Re: Marble Brewery New Building Addition
111 Marble Ave., NW
Request for Certificate of Occupancy- Transportation Development
Administrative Amendment dated 1-8-16 (J14-D140)
Certification dated 5-2-16

Project Title: Marble Brewery New Building Addition

**Re: Marble Brewery
111 Marble Ave NW
Request Permanent C.O. - Accepted
Engineer's Stamp dated: 9-1-15 (J14D140)
Certification dated: 4-11-16**

Re: Marble Brewery-New Building Addition
111 Marble Ave NW
Request Temporary 90-day C.O. - Accepted
Engineer's Stamp dated: 9-1-15 (J14D140)
Certification dated: 2-4-16

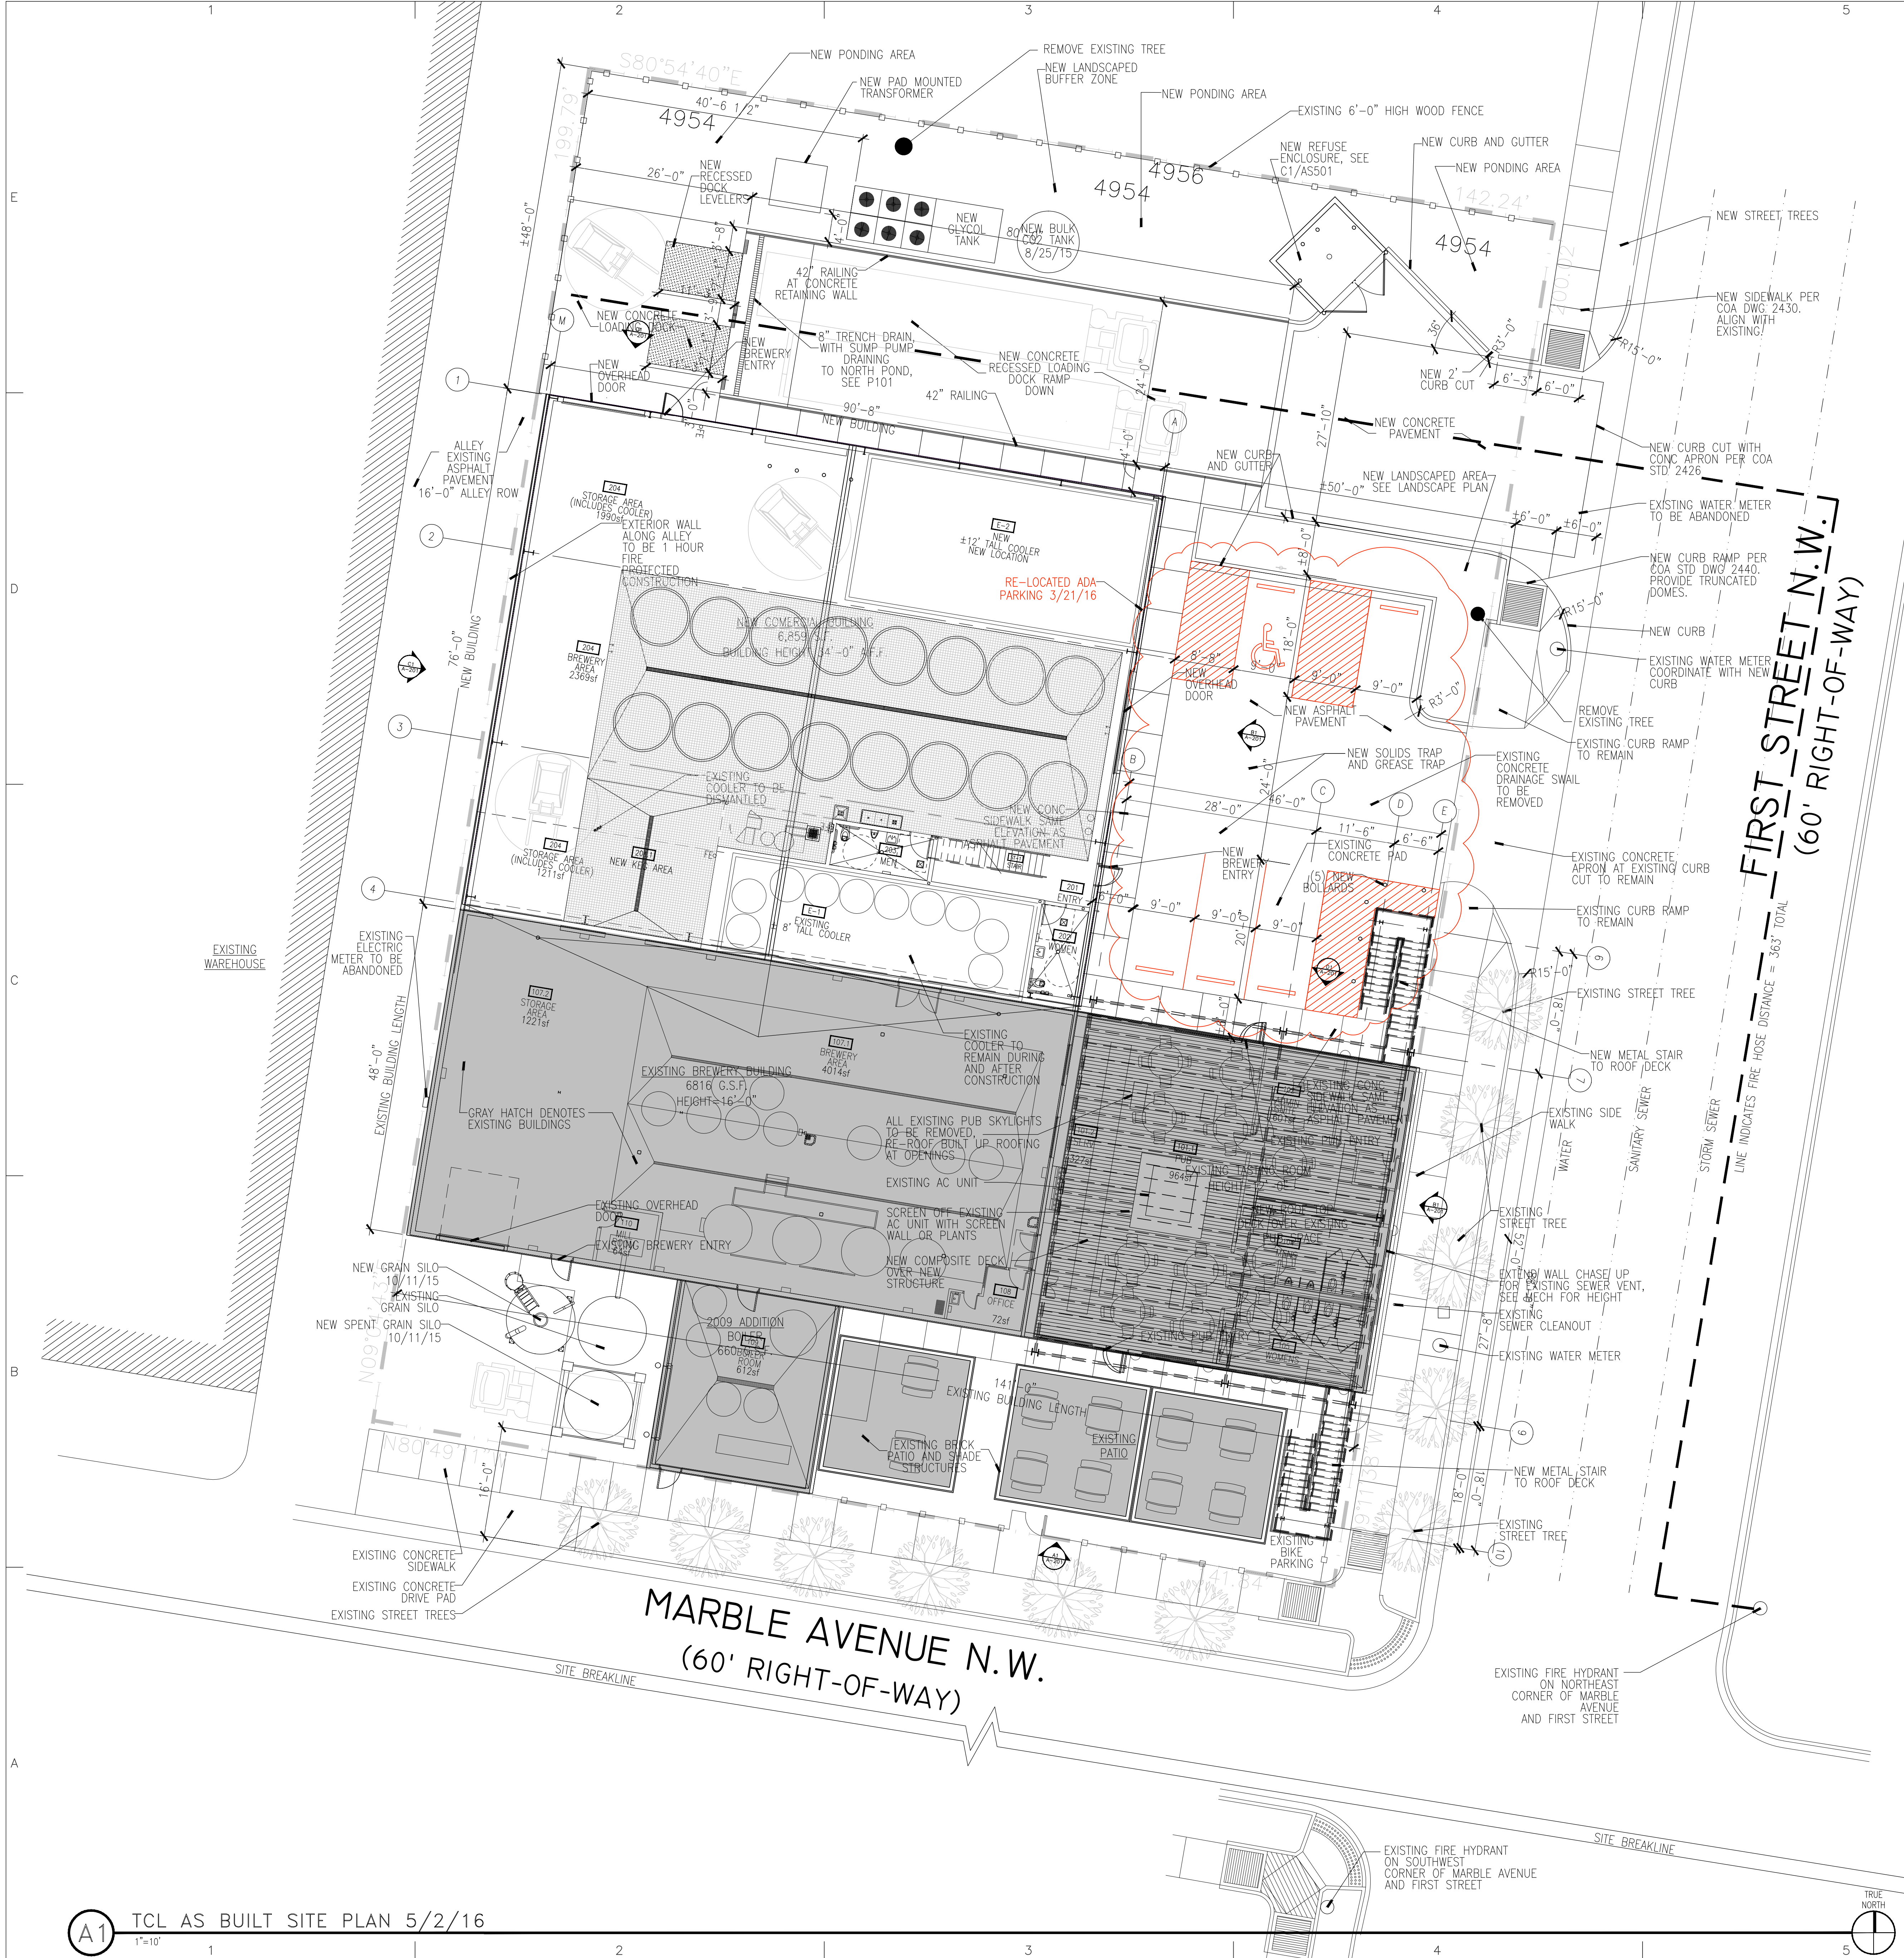
- 1.) ADA parking on north side of pub entrance was moved north on the site plan to meet the 2% grading requirement for ADA. The attached AS-Built site plan dated 5/2/16 is clouded to show changes that occurred in field for this parking area.

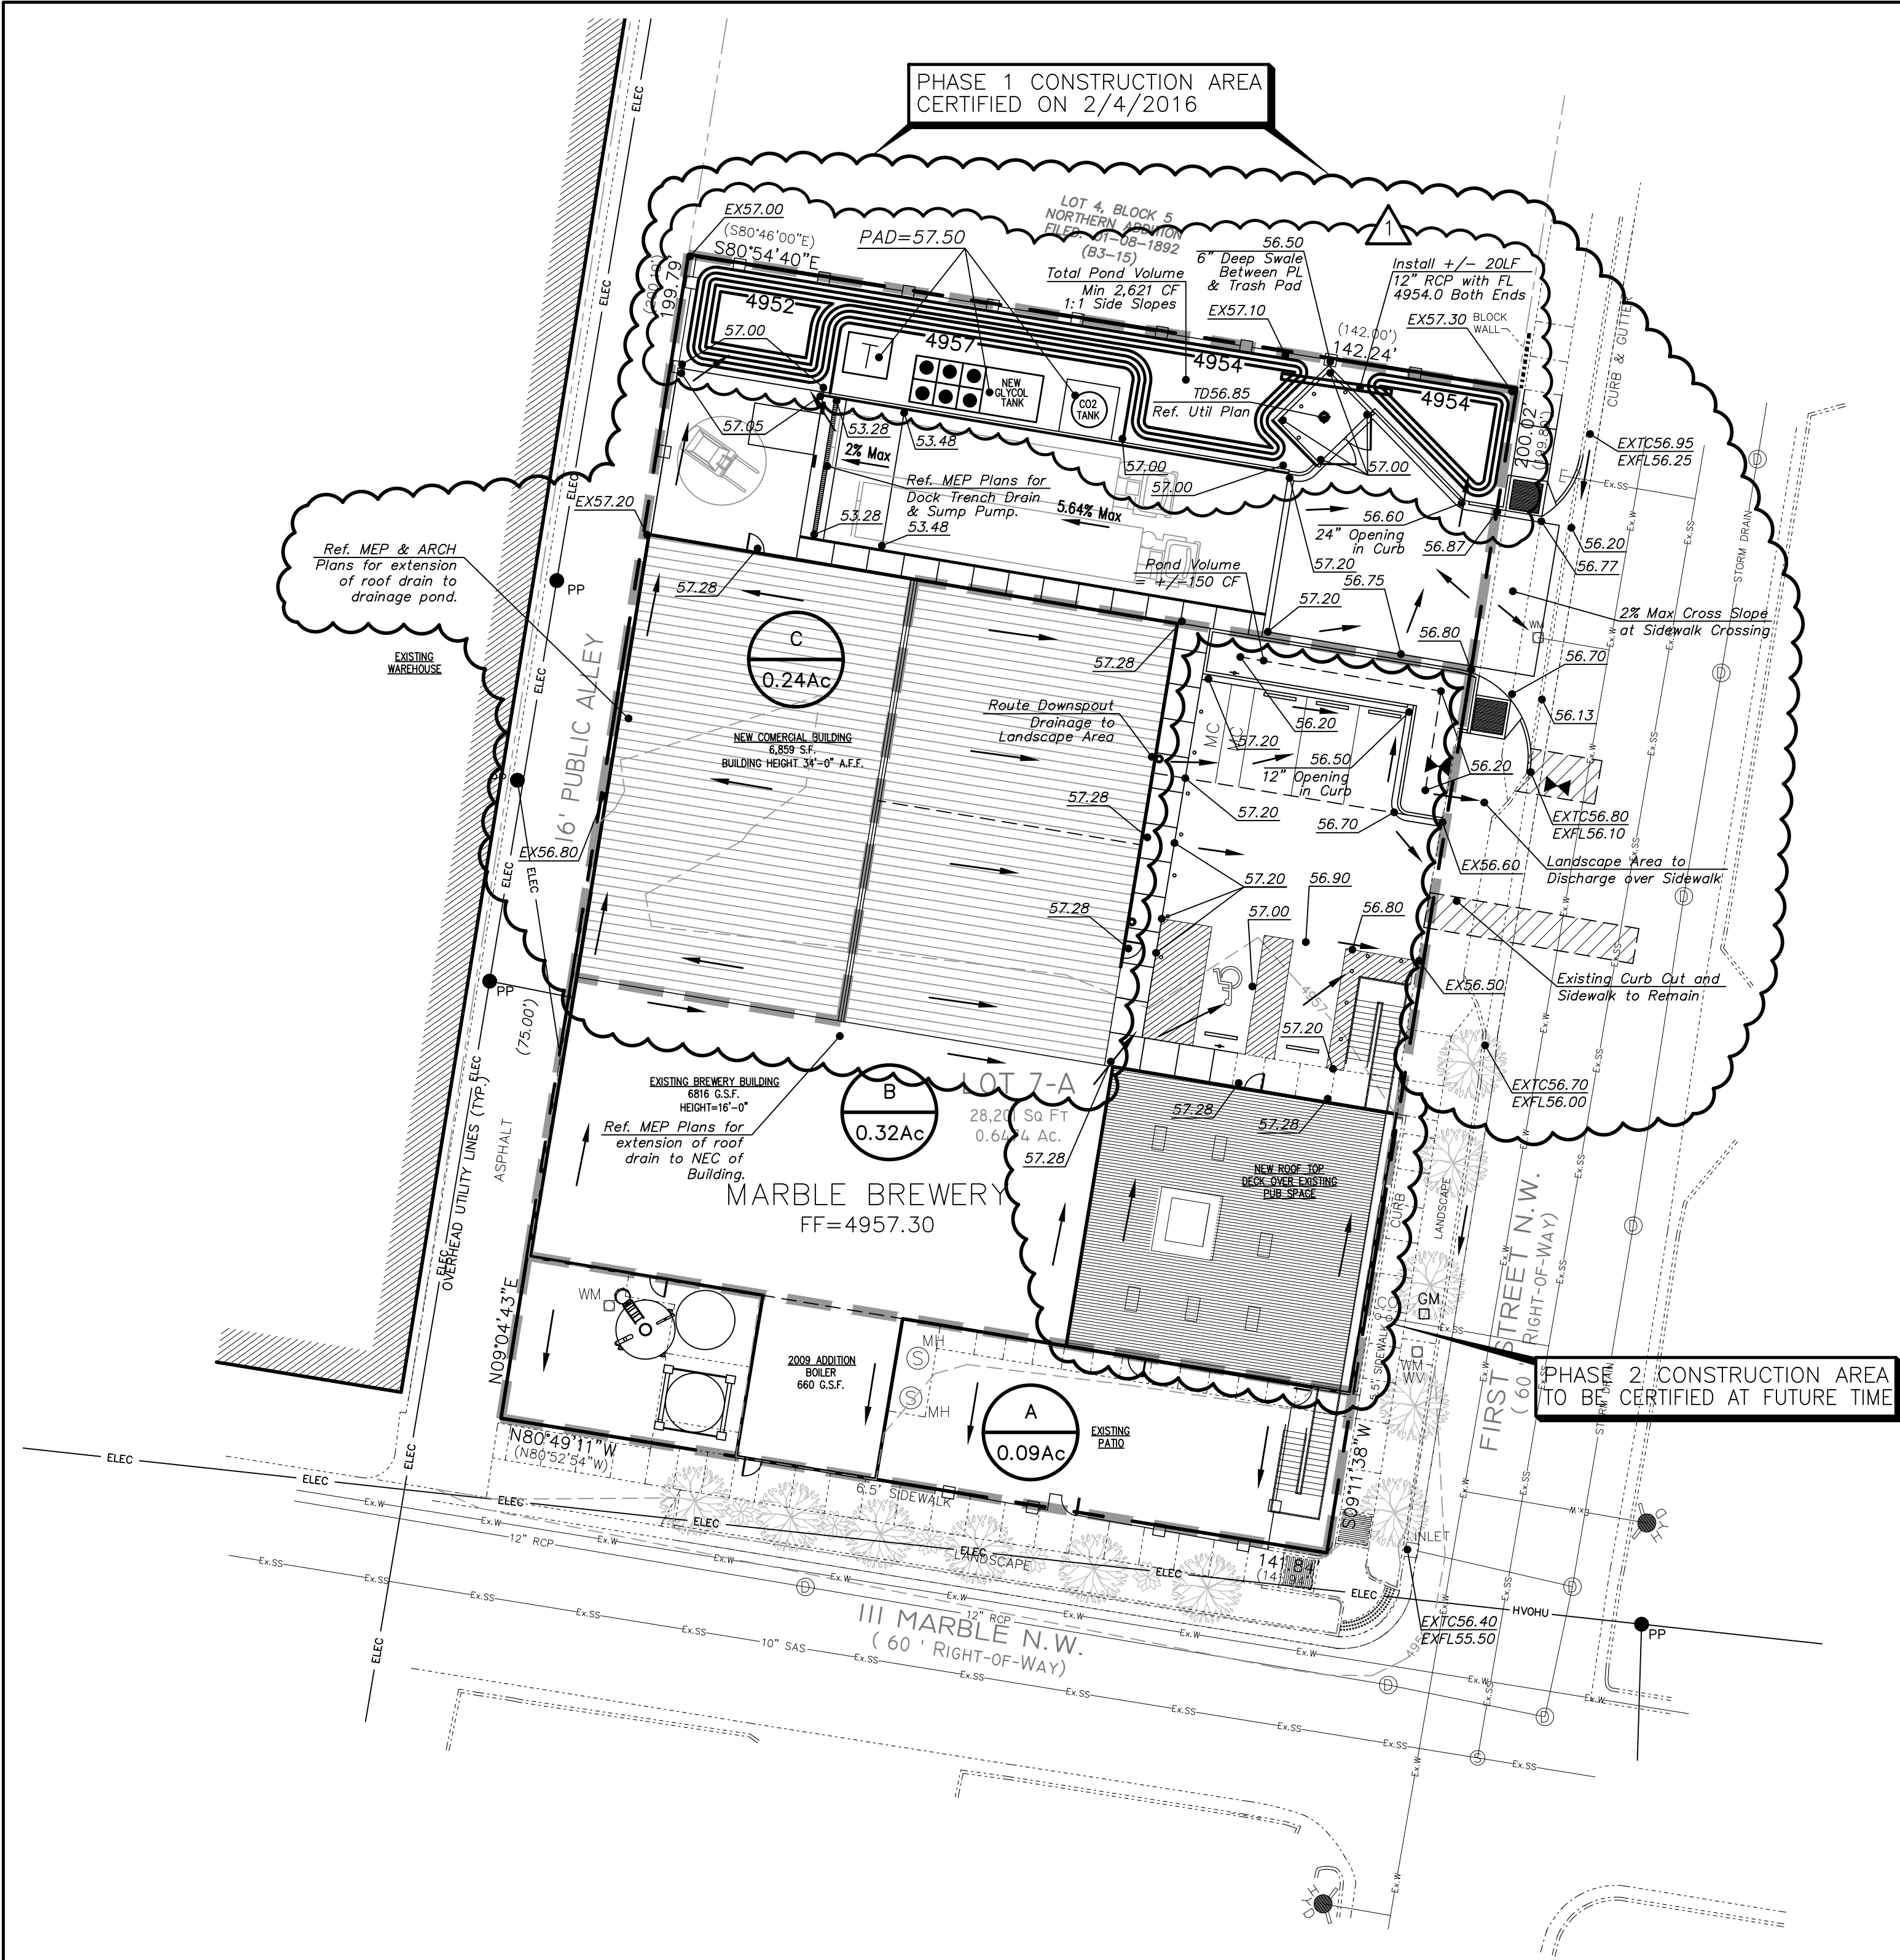
- Call out on as-built change in the dock trench drain.
- Complete construction of parking lot.
